Rezoning Petition Review

Date of Review: October 29, 2020 (*Revised November 30, 2020*)

Rezoning Petition #: 20-140

RZ1.0

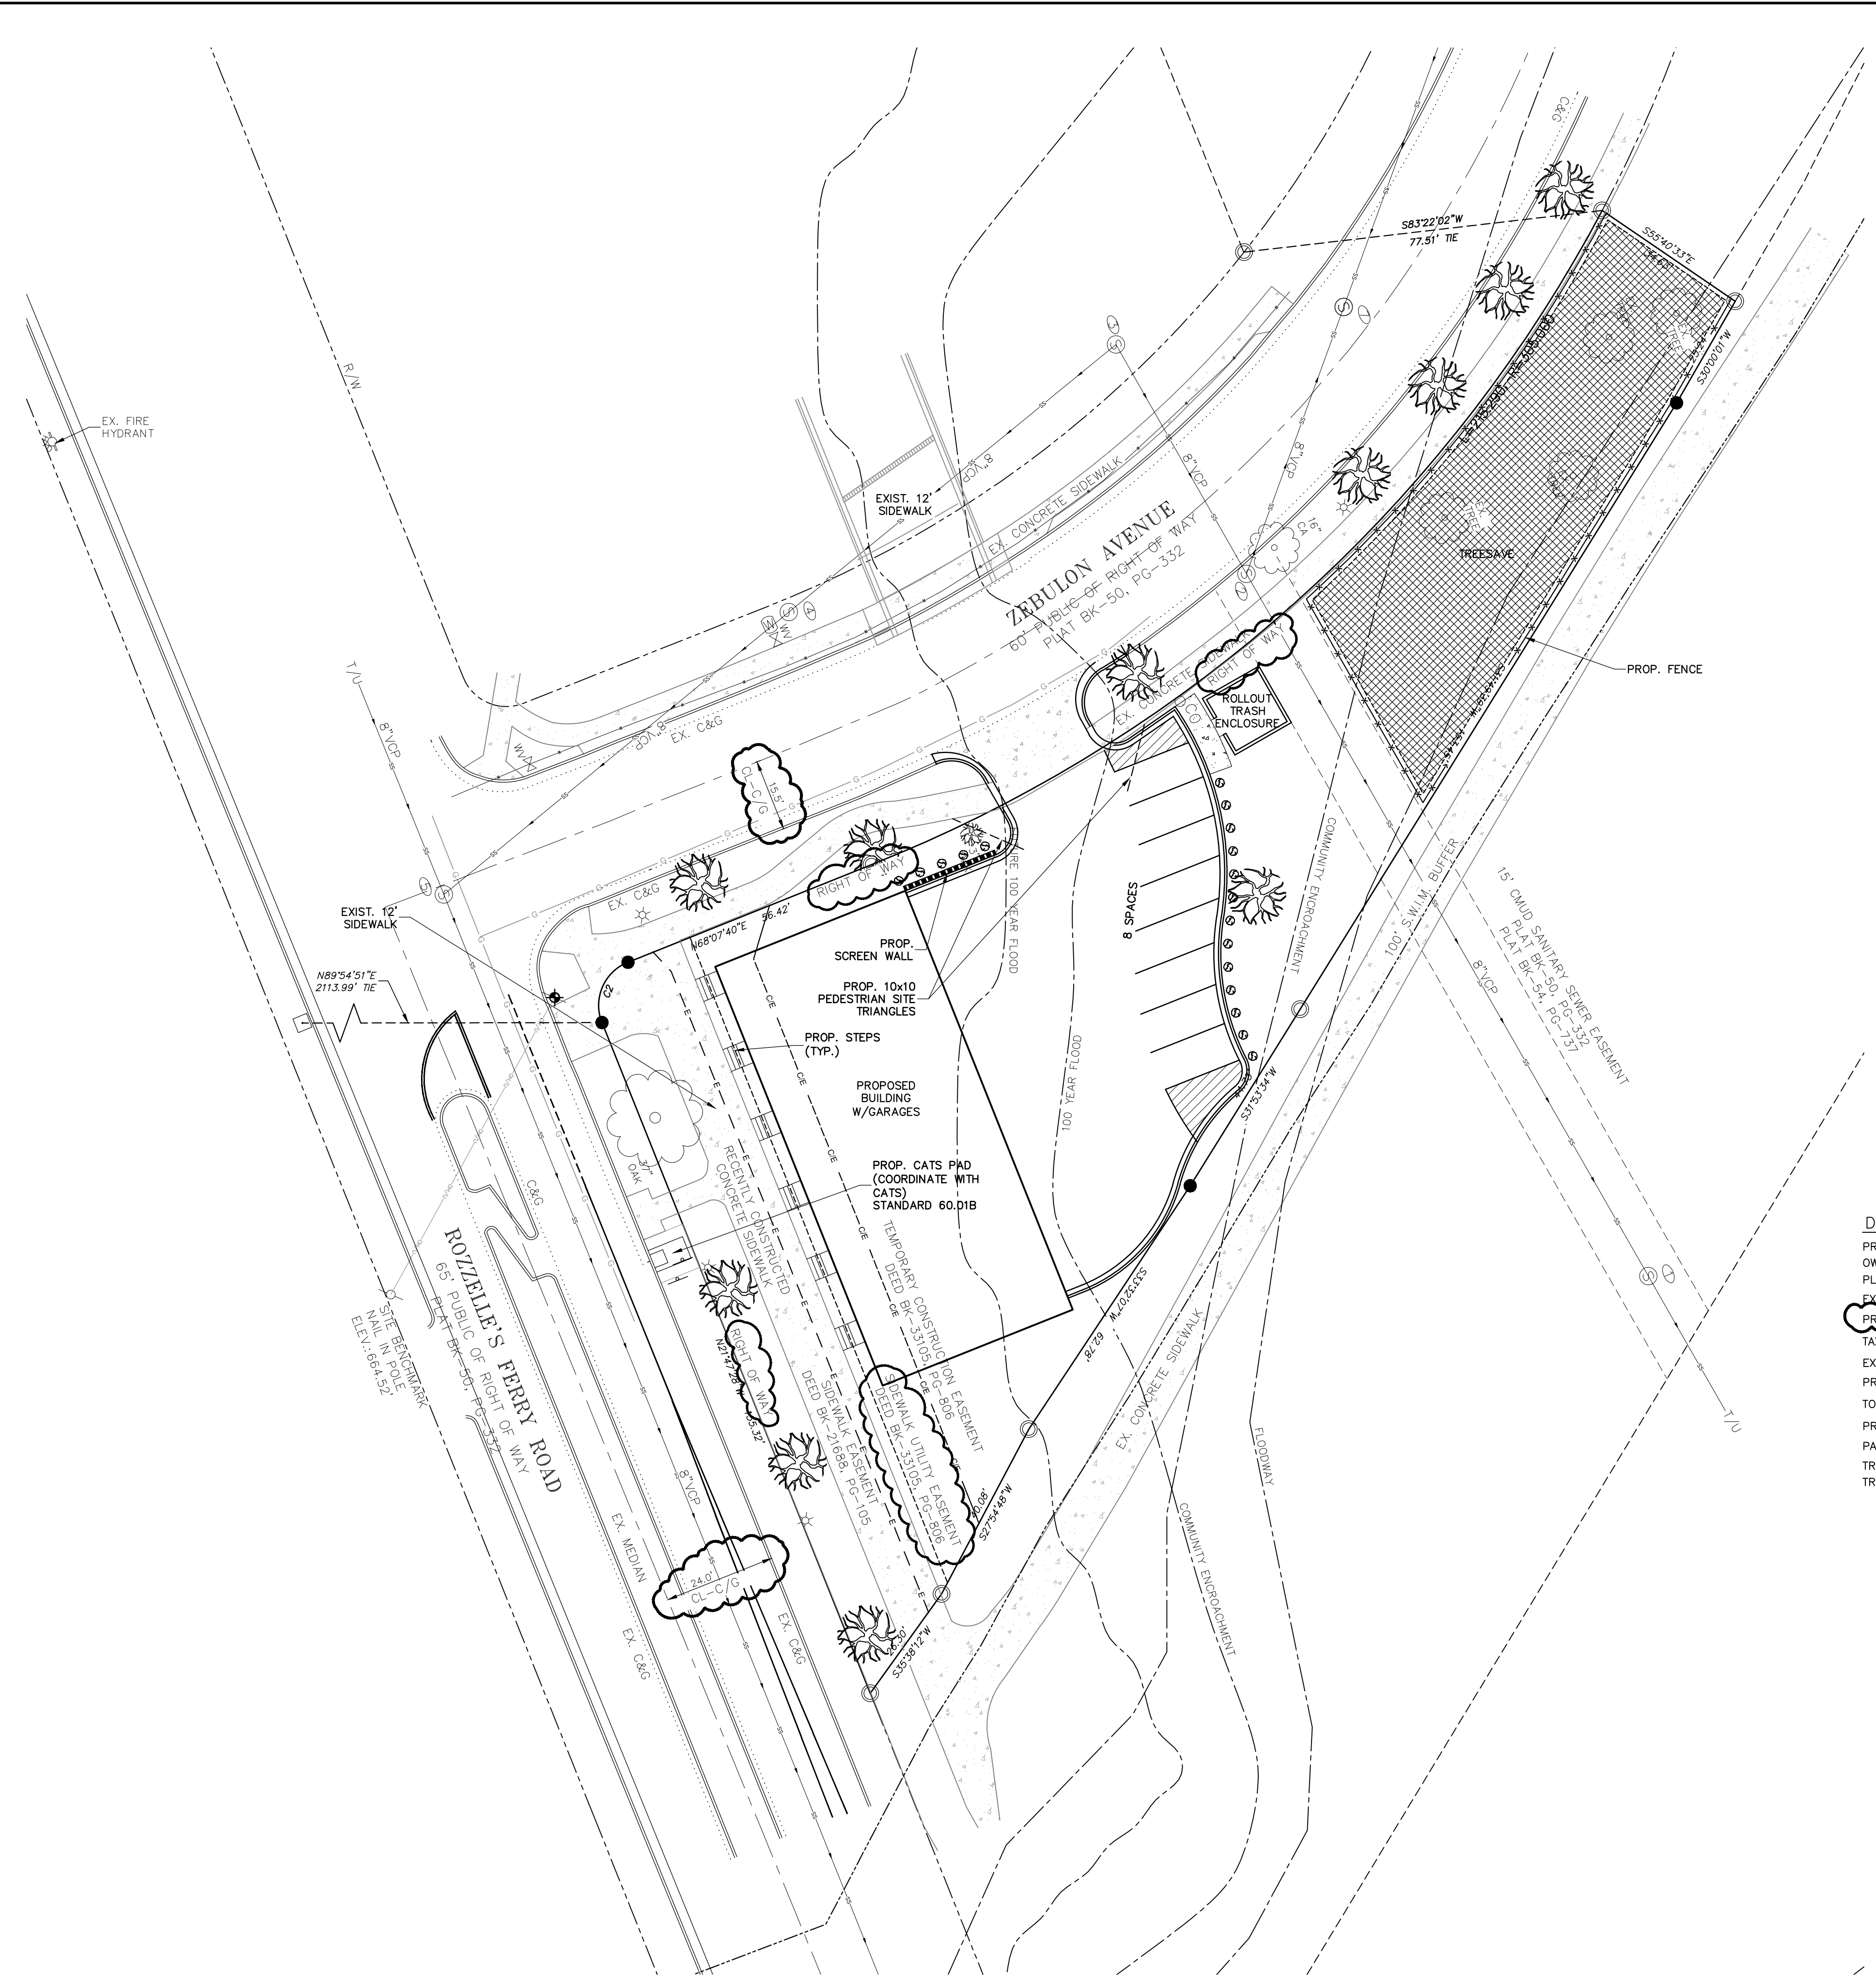
Please remove the second sentence under “Environmental Features” in its entirety. The use of existing BMP/SCMs are not approved through the rezoning process and are part of the formal plan submittal and review process.

Please include the following notes on the plan sheet under “Environmental Features”:

- *Development within any SWIM/PCSO Buffer shall be coordinated with and subject to approval by Charlotte-Mecklenburg Storm Water Services and mitigated if required by City ordinance. Petitioner acknowledges intermittent/perennial stream delineation reports are subject to review and approval upon submission of development plans for permitting and are not approved with rezoning decisions.*

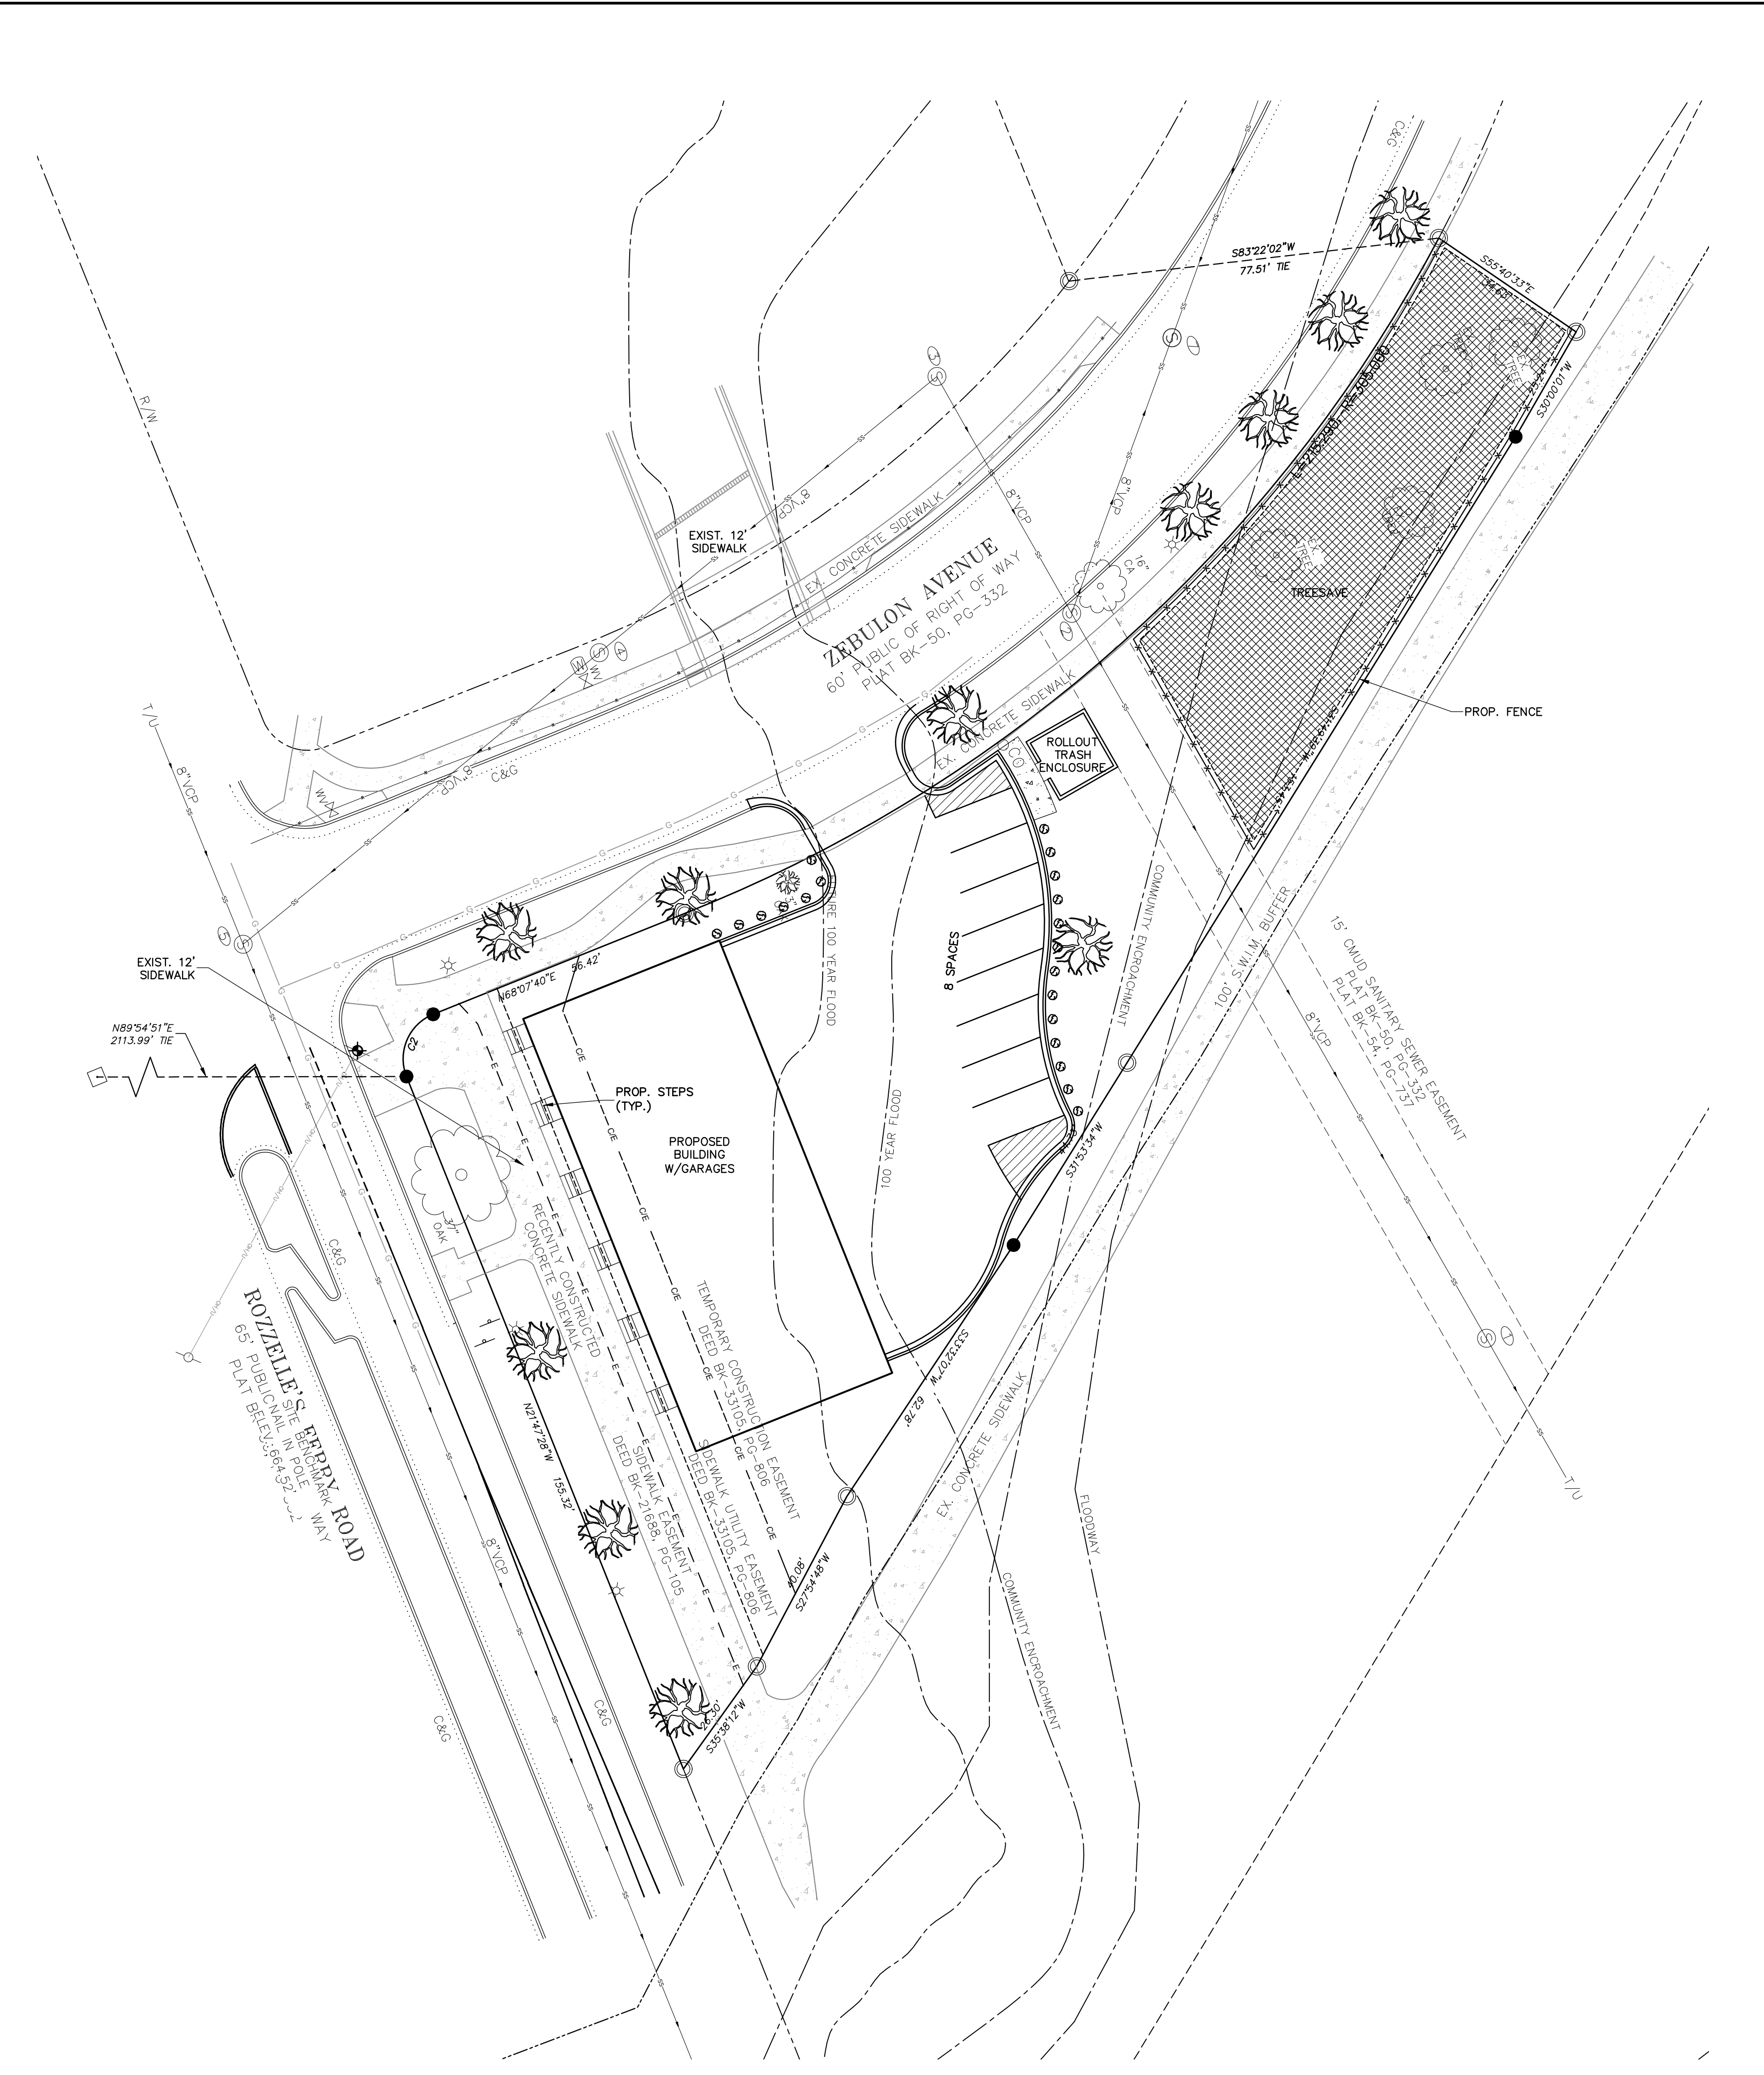
Petitioner is advised the 100’ SWIM/PCSO Stream Buffers on the site may require the inclusion of 50% of the flood fringe area as additional stream buffer. Delineation of the additional stream buffer area may be deferred to the permitting process and is not required to be shown on the rezoning plan.
